MEMORANDUM

TO: Jean Fraser
FROM: Dan Goyette, PE and Lauren Swett, EIT
DATE: April 24, 2008
RE: Portland Museum of Art, Spring Street Site Plan

Woodard & Curran has reviewed the site plan application for the Portland Museum of Art Spring Street parking lot. The Museum has purchased the former YWCA property located at the corner of Spring Street and Walnut Street, and is proposing to construct a 45-vehicle parking lot for museum employees. The project will include extensive landscaping and the construction of a bioretention cell for stormwater treatment.

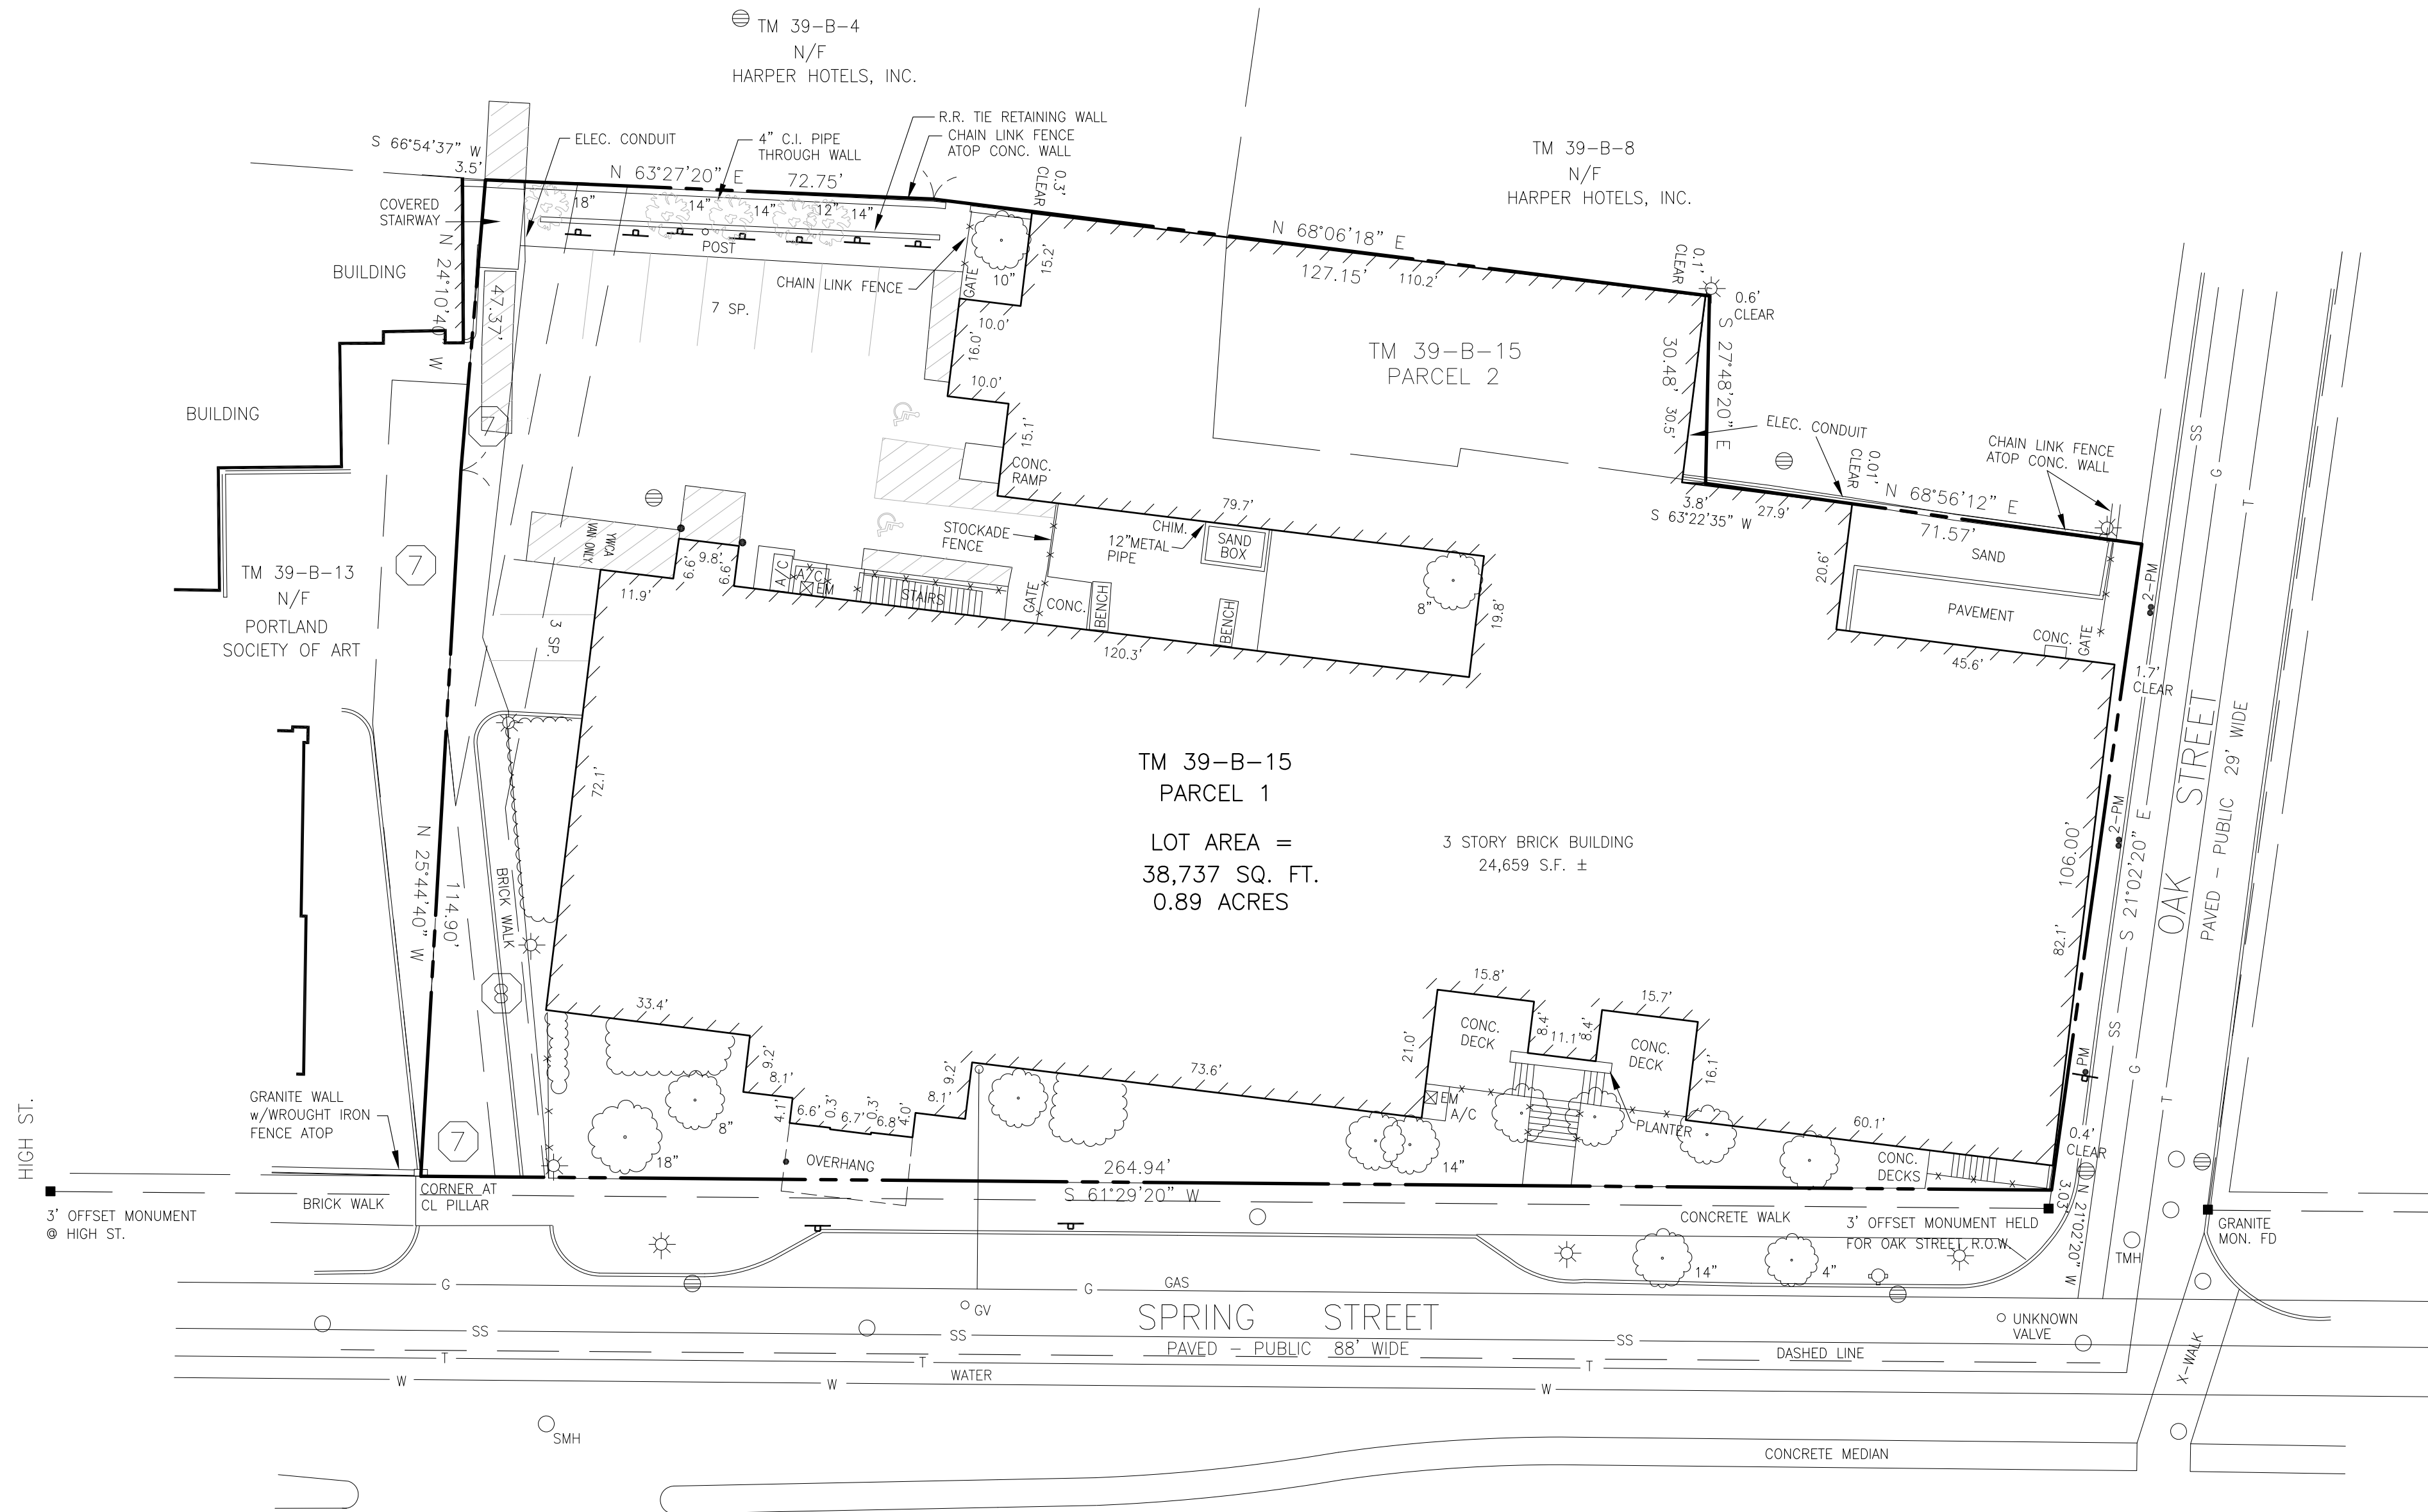
- The applicant should confirm that the survey for the project coincides with approved City standards. The survey needs to be tied to the vertical datum of NGVD 1929. Also, the project needs to be tied to the Maine State Plane Coordinate System (2-zone projection), West Zone using the NAD 1983 (HARN) Datum and the U.S. Survey Foot as the unit of measure. This should be indicated on the survey.

Job No.: 688	Dwg. No.
Date: 28 March 2008	
Scale: 1"=10'	<b>L3.0</b>
Drawn: MK	
Checked: SM

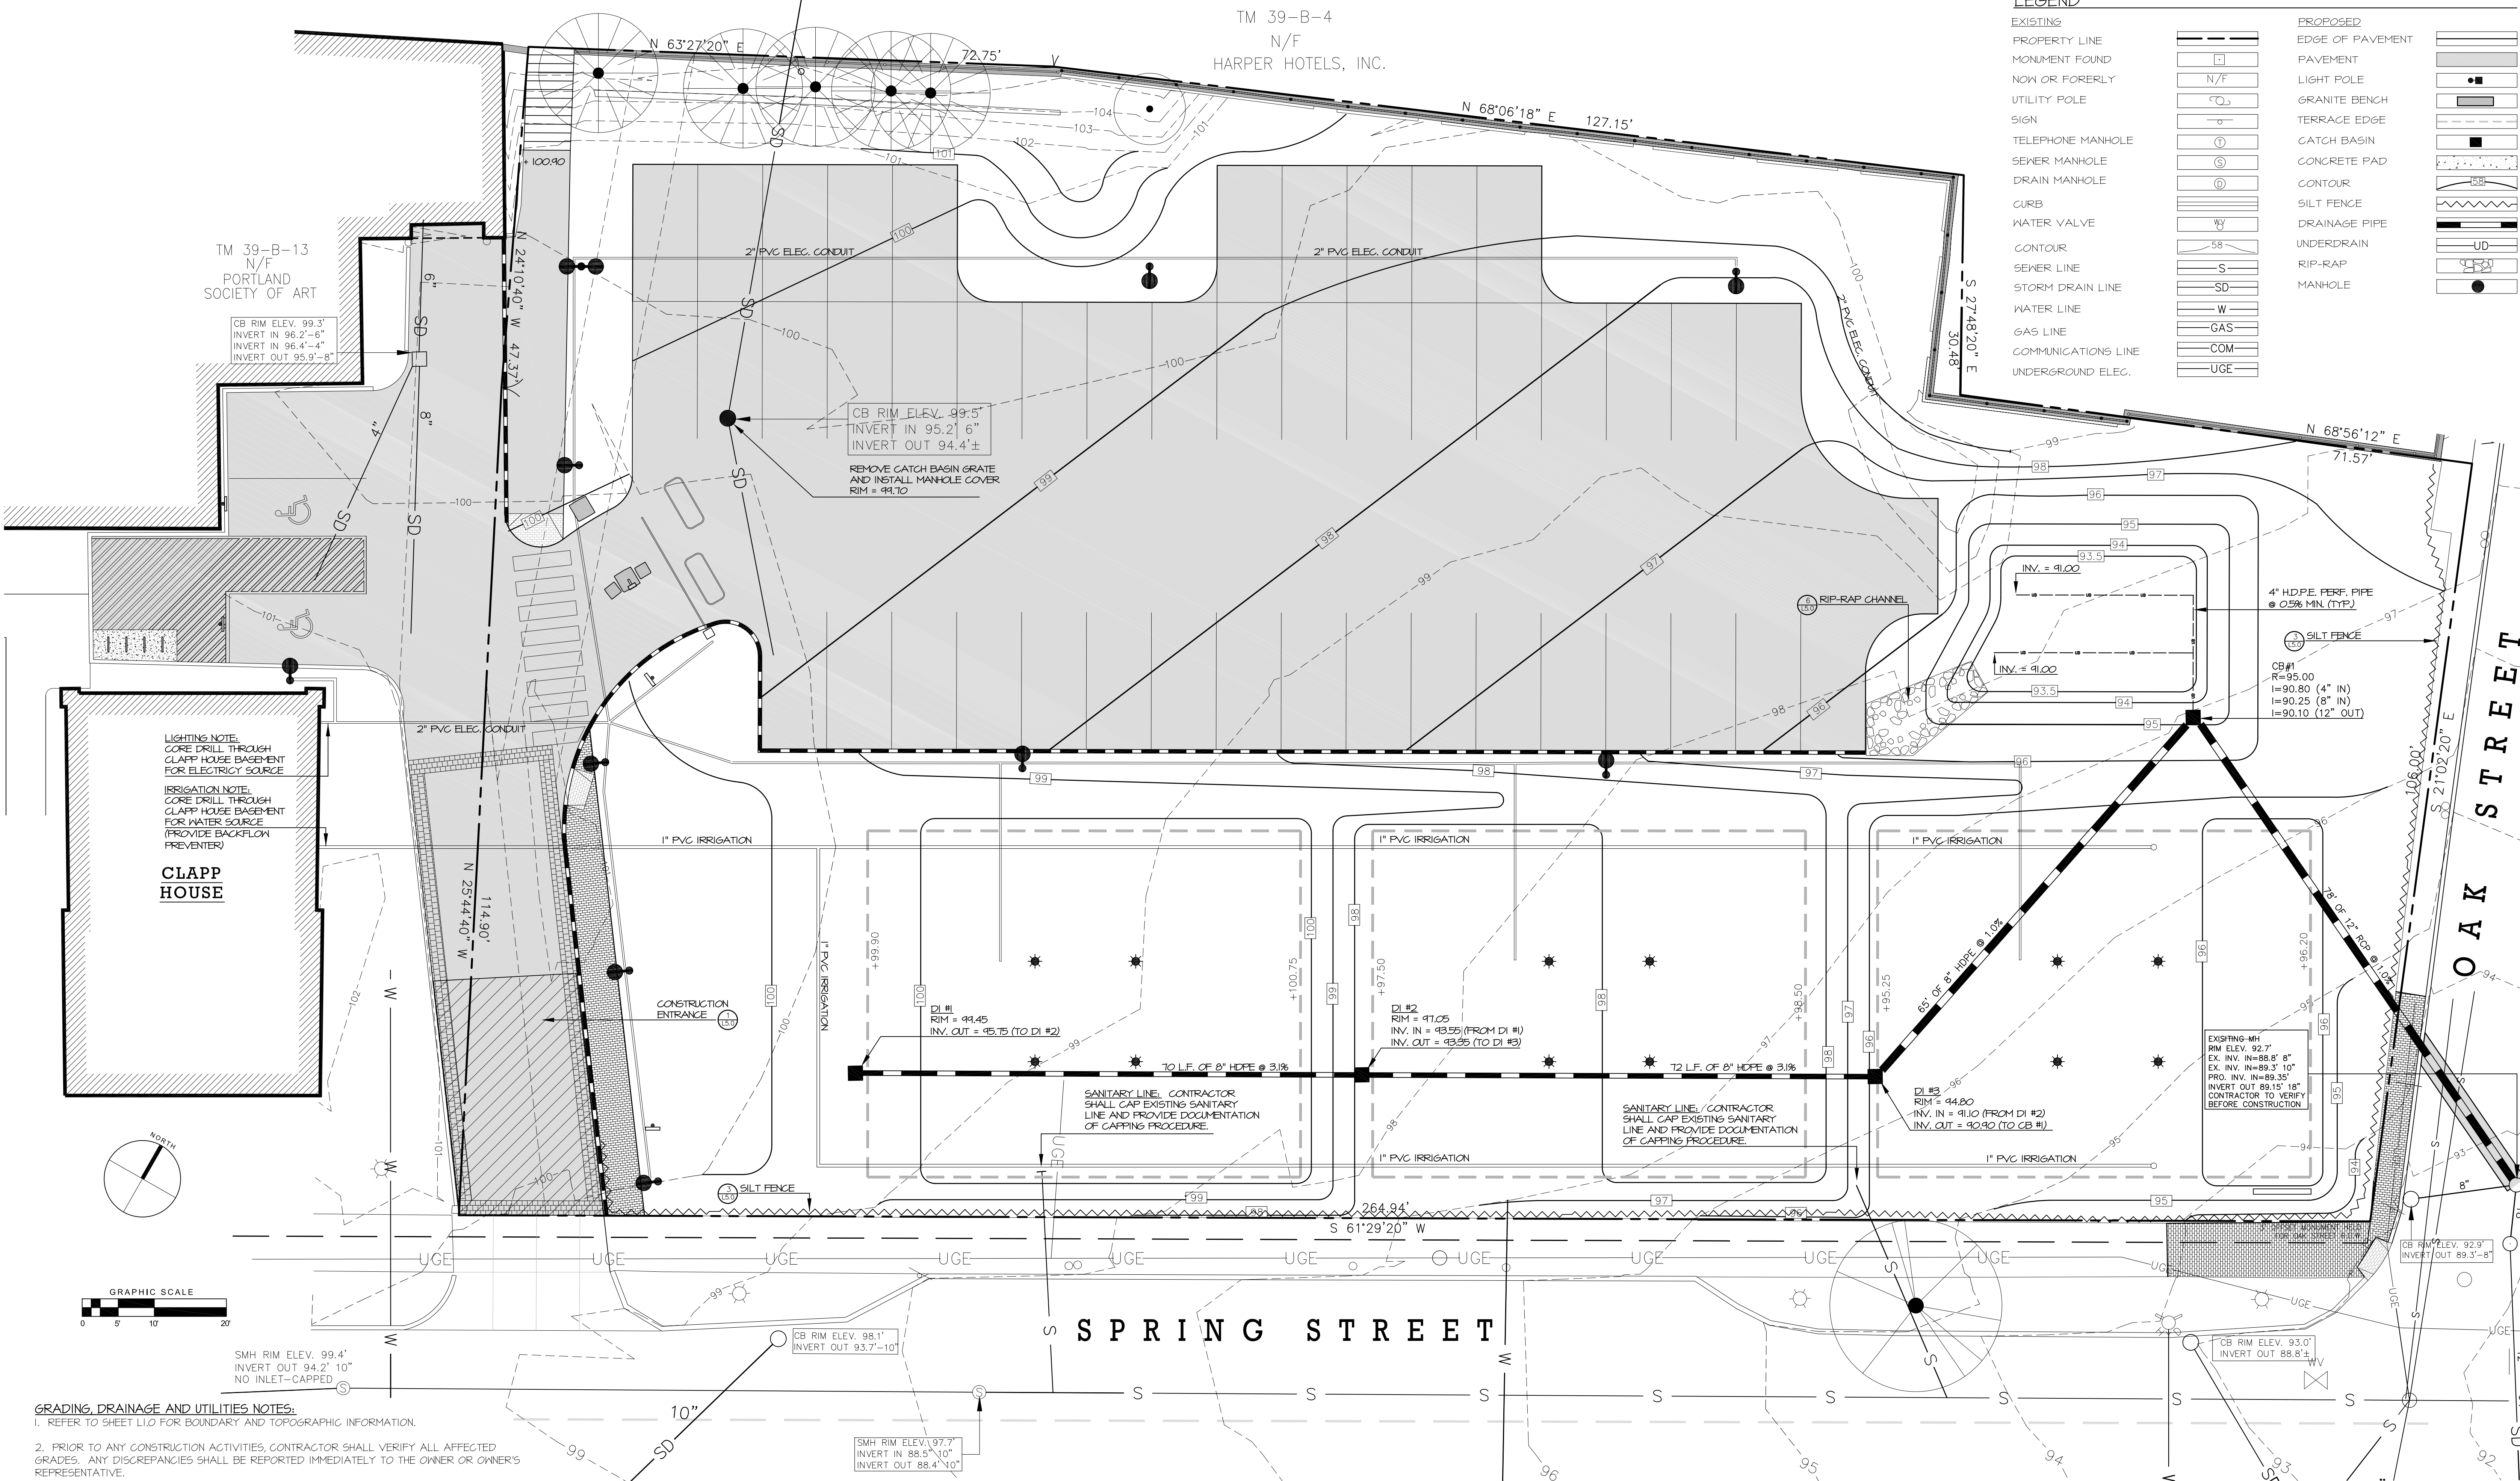
- The applicant will need to provide verification to the City that the old sewer has been capped at the sewer main.
- The applicant has proposed to tie storm drain from the site into the existing catch basin on Spring Street. This connection should either be made to the existing manhole on Oak Street or a new manhole should be provided in Spring Street. The connection directly to the catch basin will not be allowed.

- City of Portland standards do not allow the use of HDPE pipe. PVC and RCP pipes are acceptable and need to at least be used within the City right-of-way for the connections to City infrastructure.

**8 TYPICAL PIPE BEDDING DETAIL**  
L5.0 NOT TO SCALE

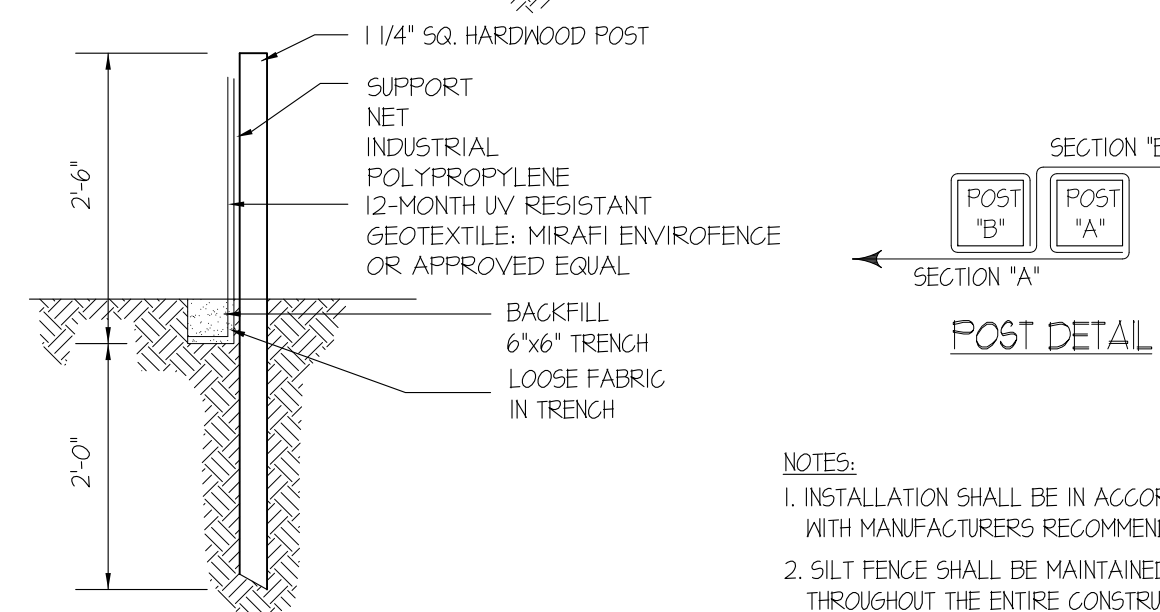
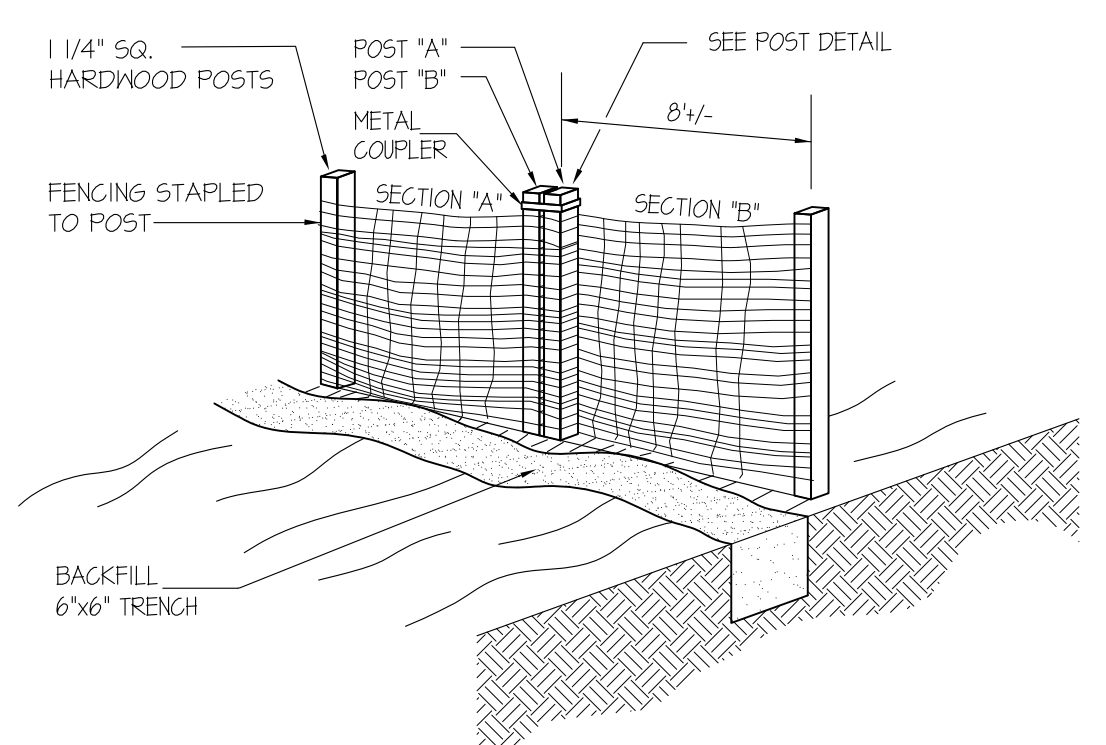
- The landscaping plans and the engineering plans both include details for pipe trenches. These details should be the same and should show crushed stone above and below the pipe.
